Re: PA23-008, Krykun's Duplex - *Technical Review 2*
Location: 10408 Shoultes Road

The Planning Division has reviewed the above referenced application and has the following comments:

COVER SHEET

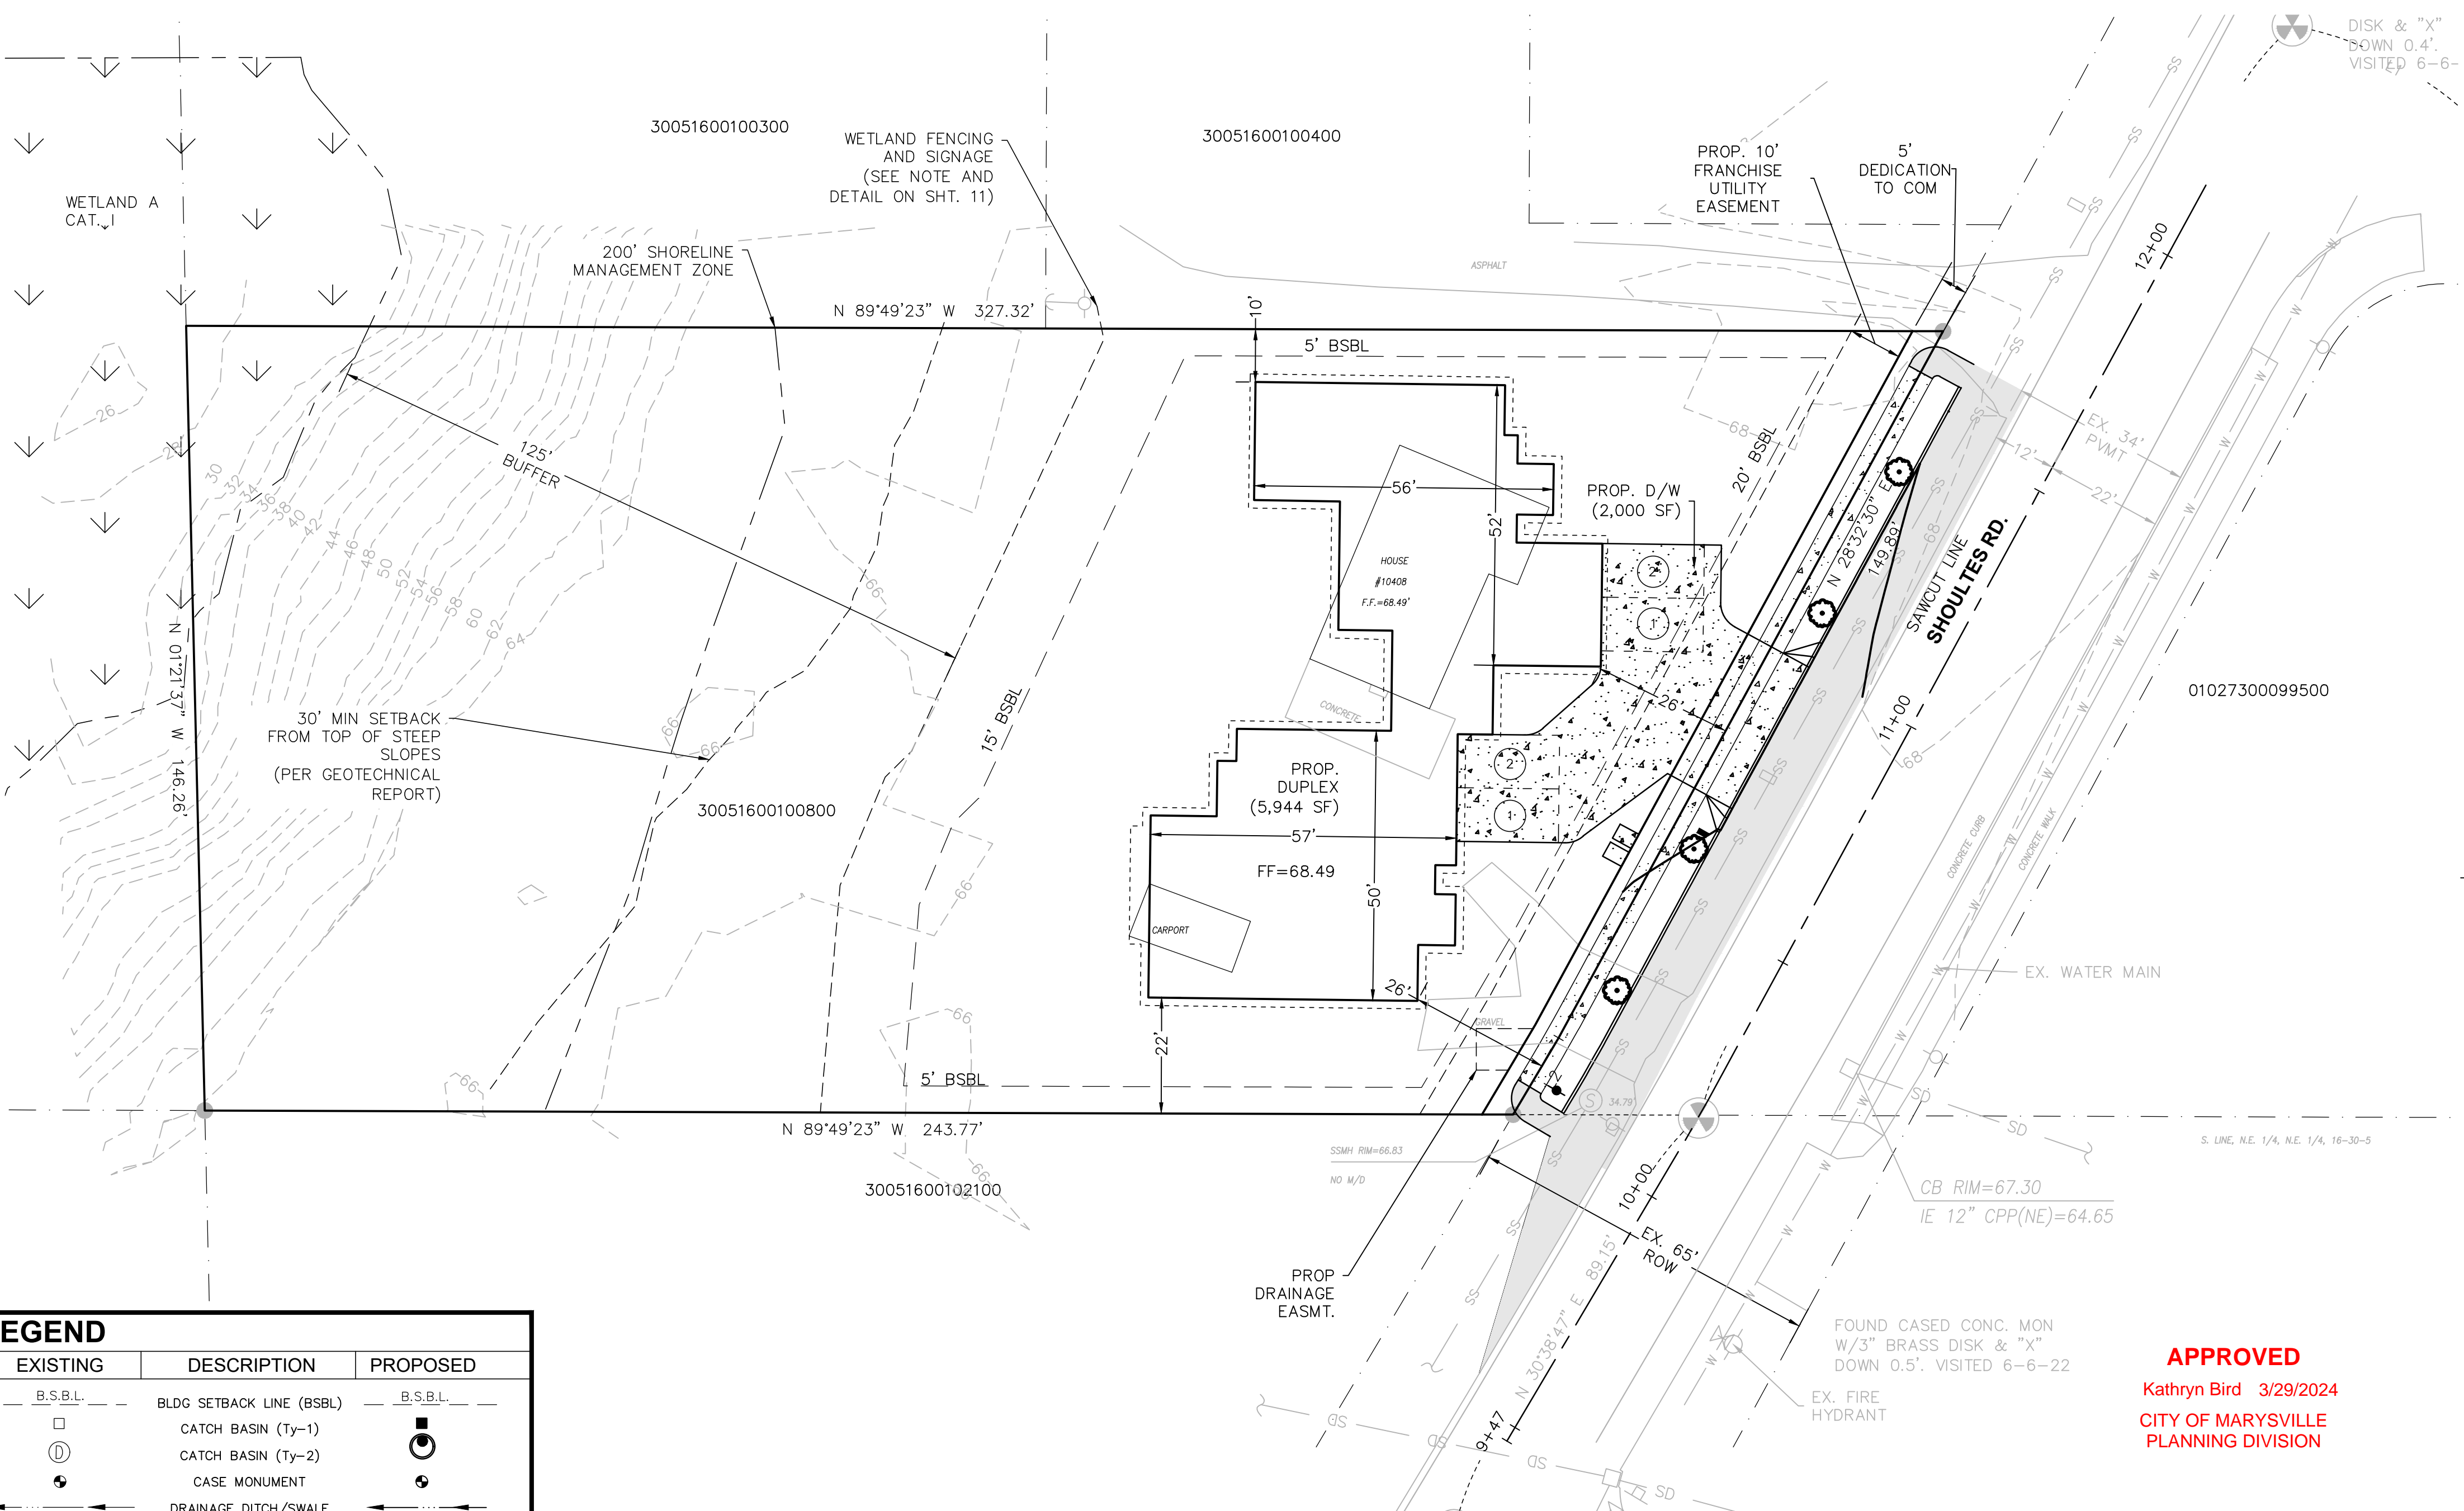
- b. Update the impervious surface and building coverage as needed.
